| REQUEST | Current Zoning: UMUD, urban mixed use development Proposed Zoning: UMUD-O, urban mixed use development optional |
| LOCATION | Approximately 5.43 acres bounded by South Brevard Street, South Caldwell Street, East Stonewall Street, and East Martin Luther King Jr. Boulevard. |
| SUMMARY OF PETITION | This petition seeks approval of an optional request to allow additional signs and allow the required street trees to be relocated into the plaza area of the site. |
| STAFF RECOMMENDATION | The proposed land use is consistent with the adopted land use plan for this site; however, staff is not recommending approval of the optional request for the relocation of street trees. |

STREET TREE EXCEPTION OVERVIEW

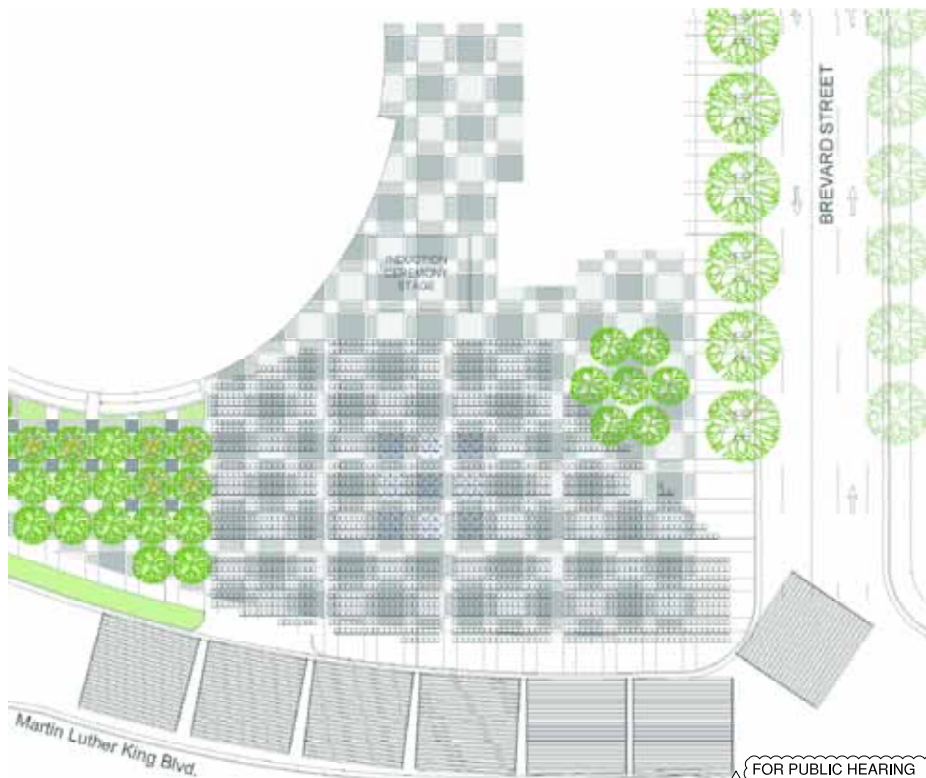
- **Storm Water** has no comments on this petition.
- **LUESA** has not commented on this petition.
- **Site Design:**
 - Reduces ground level temperatures by providing tree canopy with the exception of the area along Martin Luther King Boulevard at Caldwell.

1. The petitioner should provide examples of the types of signs.
2. The petitioner should relocate sign number S-6 from the middle of the sidewalk. The large amount of anticipated pedestrian traffic from bus loading and drop off will be impeded by a sign in this location.
3. The petitioner should relocate sign number S-5 out of the setback to avoid safety issues.
4. The petitioner should provide street trees along Martin Luther King Boulevard at Caldwell. Staff does not support the relocation of the street trees along Martin Luther King Boulevard at Caldwell. The need for additional area for spectators does not warrant this optional request. The trees serve as a buffer between vehicle traffic and pedestrians. In addition, the daily comfort zone created by the street tree canopy and the tree canopy link that joins uptown projects should be preserved.
